**Planning Application No: 3/2025/0167**

**Proposal: Proposed annexe accommodation.**

**Location: Willow Spring 58 Pendleton Road Wiswell BB7 9BZ**

Tahira Akhtar BA (Hons)  
Technician  
Highway Development Control  
Highways & Transport  
Lancashire County Council

Scale 1:200
SITE PLAN

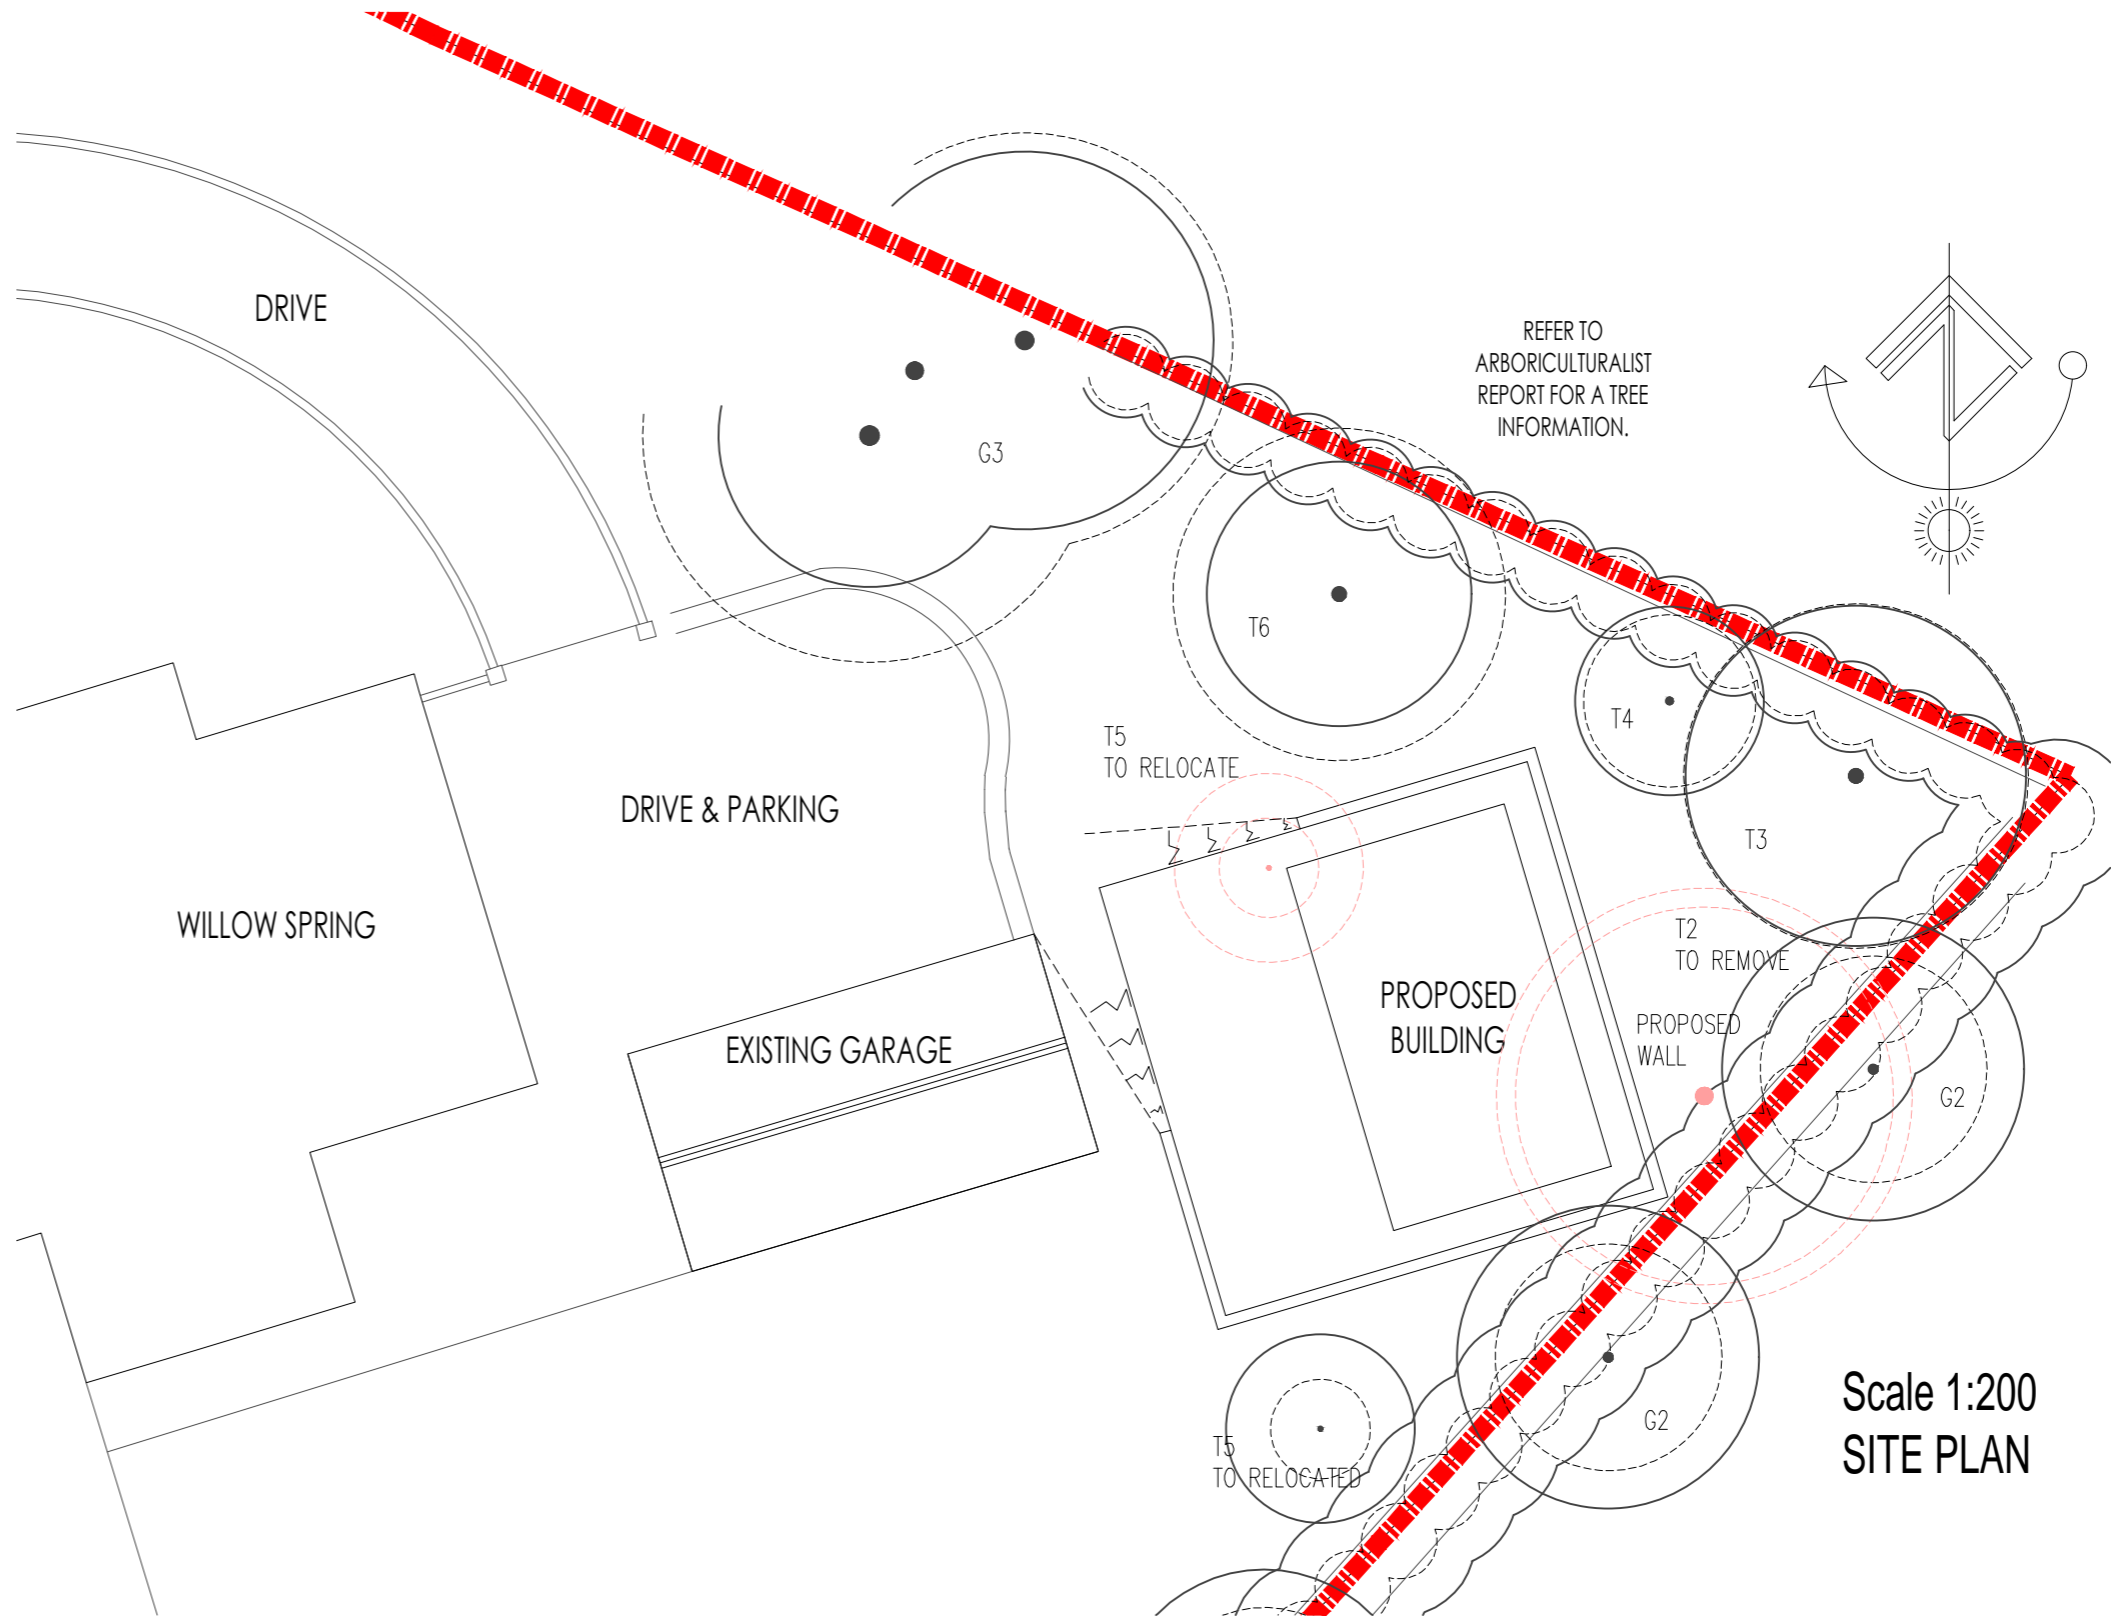
As the proposal is not for an independent dwelling; it is proposed annexe accommodation with the annex to be an art studio/living room with one bedroom and no kitchen. It is recommended that a minimum of 1 bicycle space is provided for the annexe proposed.

- Space shall be provided for a minimum of 1 bicycle for a 1-bedroom dwelling.  
Reason: To allow for the promotion of sustainable forms of transport and aid social inclusion.
